PLANNING CONSULTATION RESPONSE

Application No	2026/0484
Proposal	Removal of existing garage and attached store and construction of new domestic double garage together with adjustments to drive and patio/path area
Address	24 Birks Lane, Millhouse Green, Sheffield, S36 9NB
Date of Consultation Reply	13/07/26
Consultee	Highways DC

PROPOSED
Site Plan - 24 Birks Lane

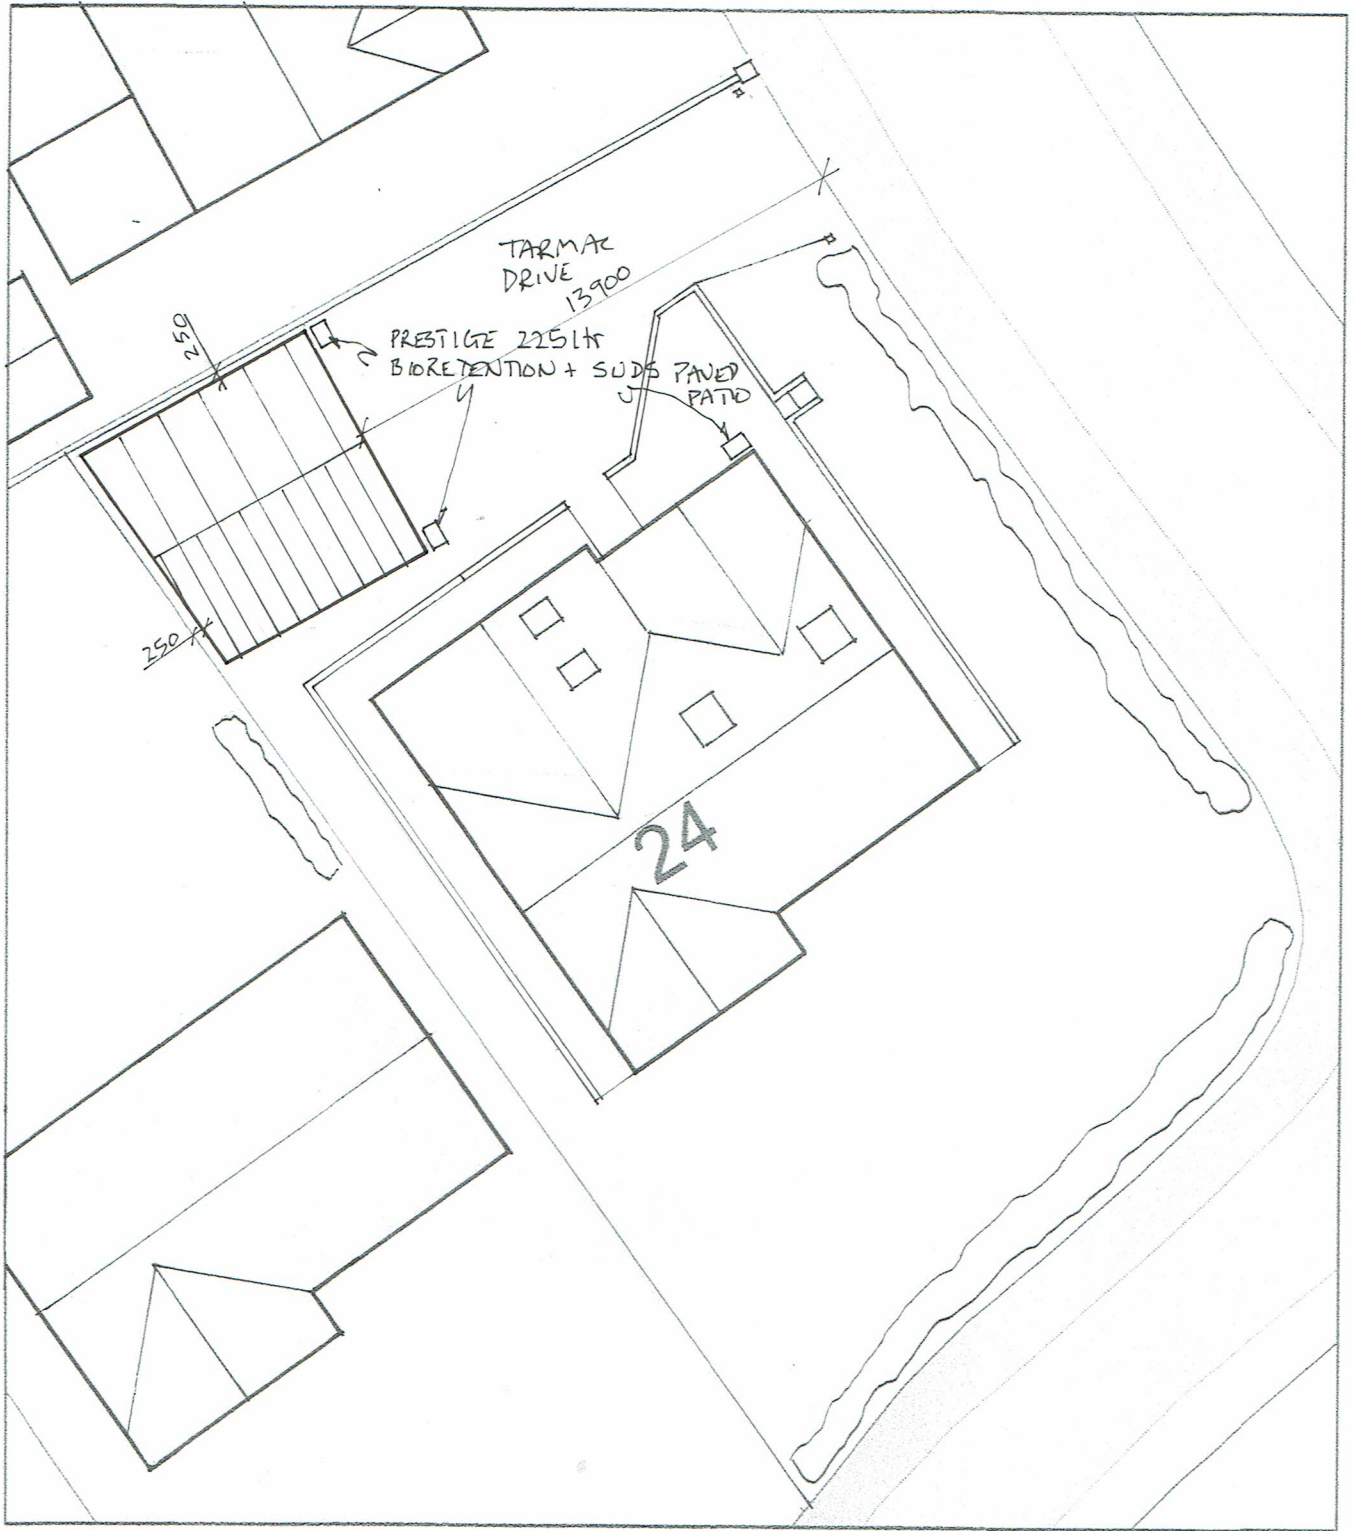
The proposal replaces an existing garage served off Birks Avenue with a larger garage able to house two vehicles. Alterations to the driveway also make it easier for vehicles to enter and exit without reducing the off-street parking provision.

The parking facilities as indicated on the submitted plan shall be surfaced in a solid bound permeable material (i.e. not loose chippings) and adequate measures shall be so designed into the proposed access to avoid the discharge of surface water from the site on to the highway.
Reason: To ensure adequate provision for the disposal of surface water and to prevent mud/debris from being deposited on the public highway and to prevent the migration of loose material on to the public highway to the detriment of road safety and in accordance with Local Plan Policy T4 New Development and Transport Safety.
